Our Ref: R/2016/1/D
File No: MP 08_0098 MOD 13

The Star (MP08_0098 MOD 13) – 20-80 Pyrmont Street, Pyrmont – Response to Submissions

The City of Sydney (the City) has reviewed the RTS and maintains its **objection** as the issues raised in the City's letter dated 9 October 2018 remain unaddressed. The following additional comments are provided for your consideration:

TYPICAL PLANTER SECTIONS

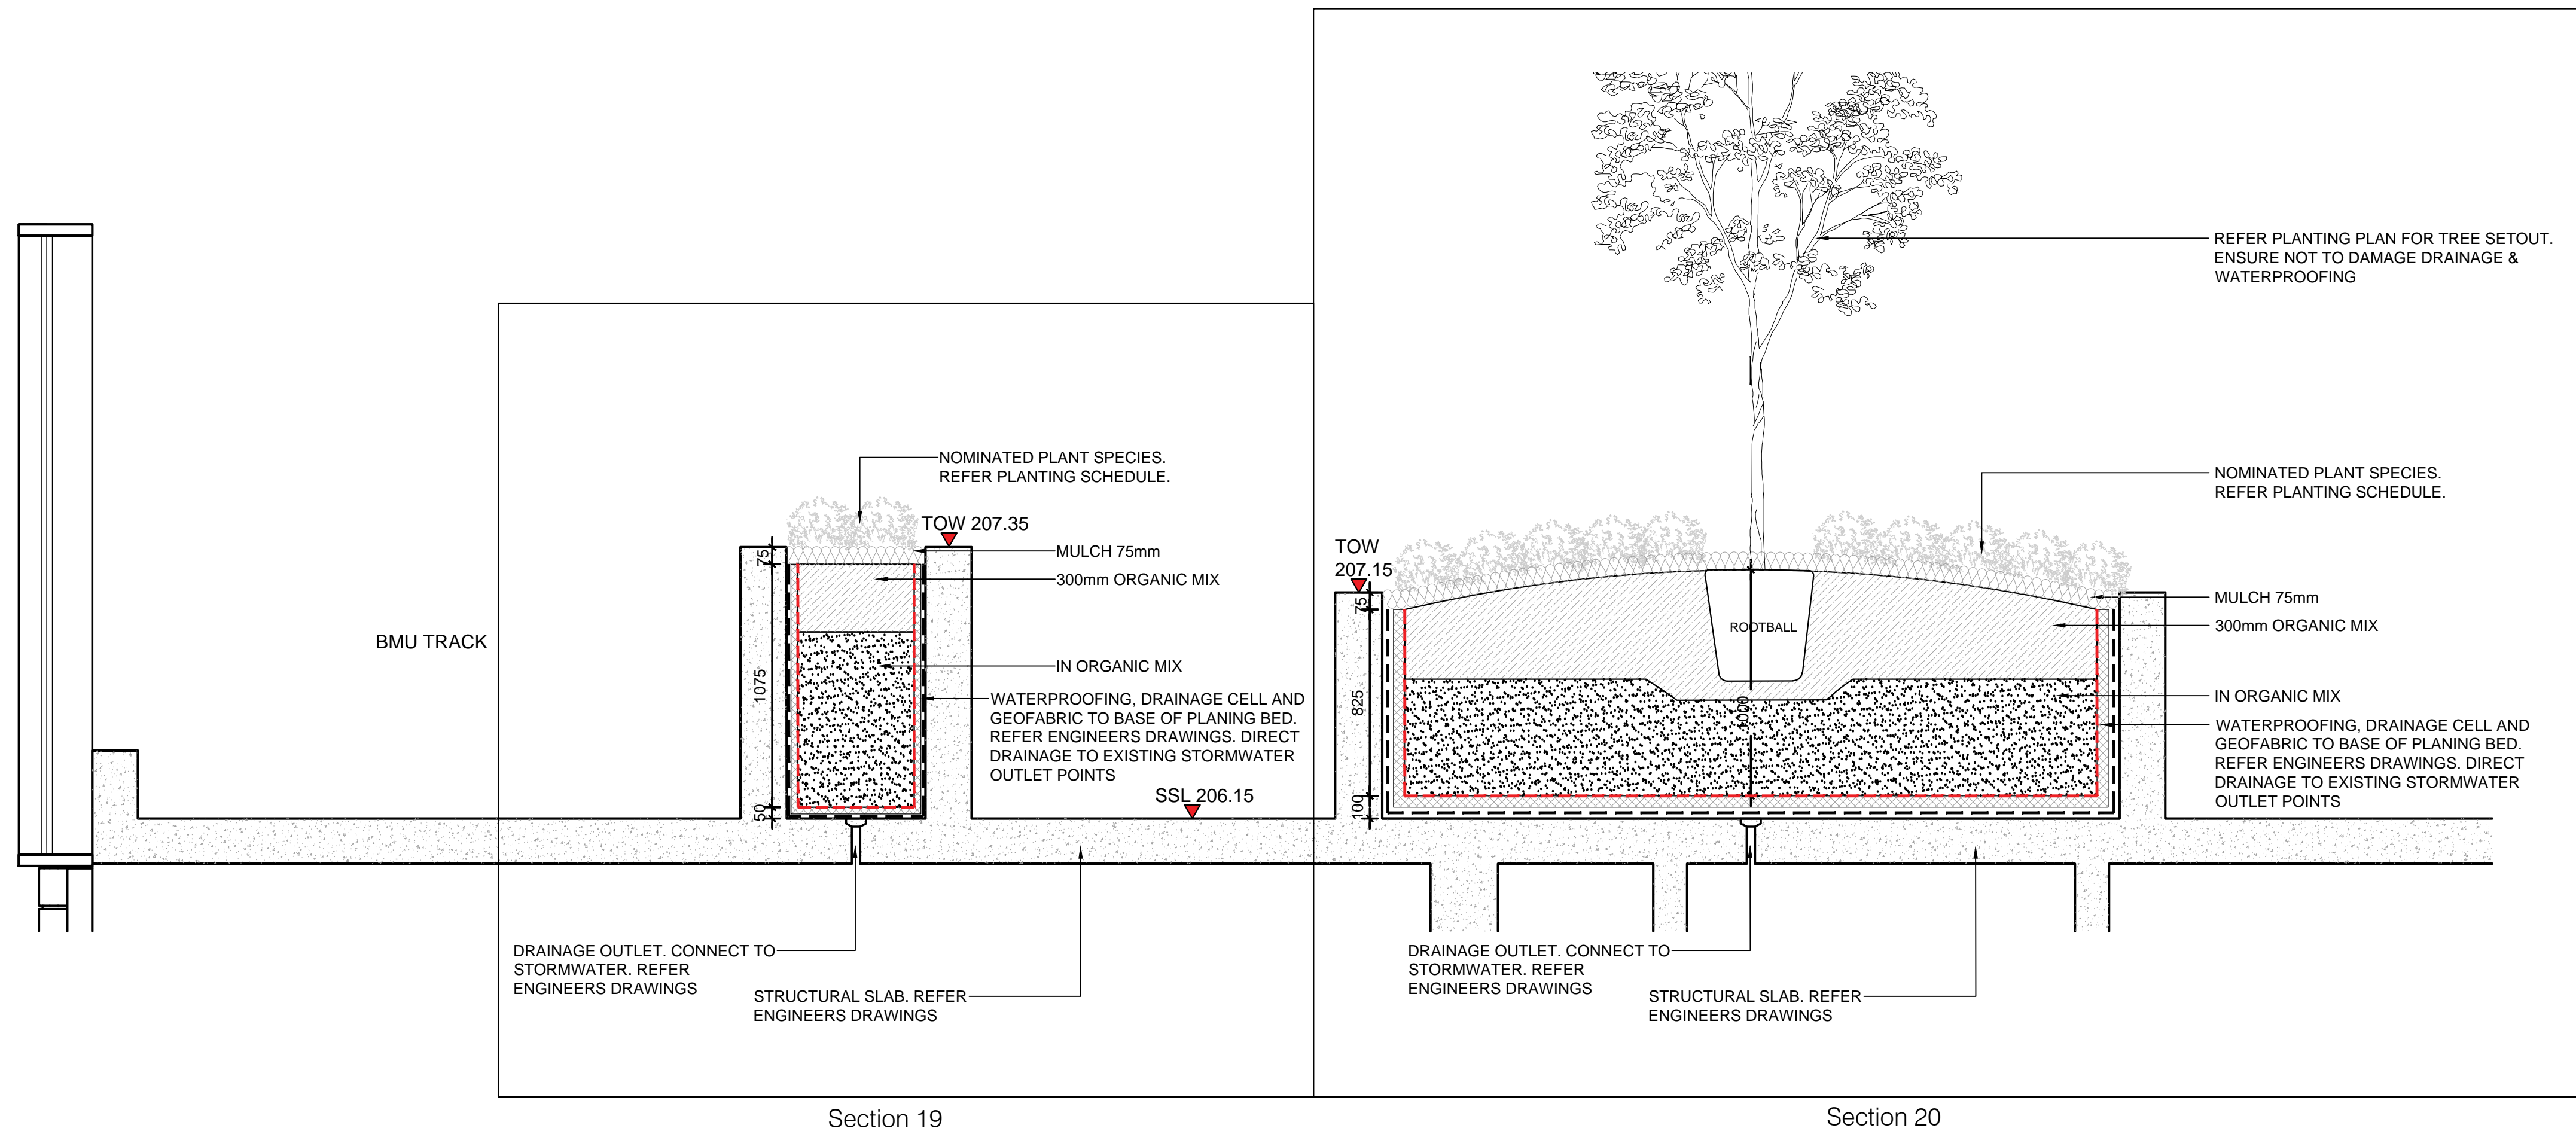
The applicant has confirmed minimum soil depths will be in accordance with the Landscape Code Volume 2 and the ADG as noted in table below, which is supported. However, several typical planter sections for planting on podium shown on Dwgs L900-902 [A], do not reflect the minimum depths which is not supported.

It is recommended that the landscape design should ensure that minimum soil depths (or higher) are achieved to ensure a high quality landscape outcome. It is noted that the minimum soil depths are in addition to drainage and mulch layers.
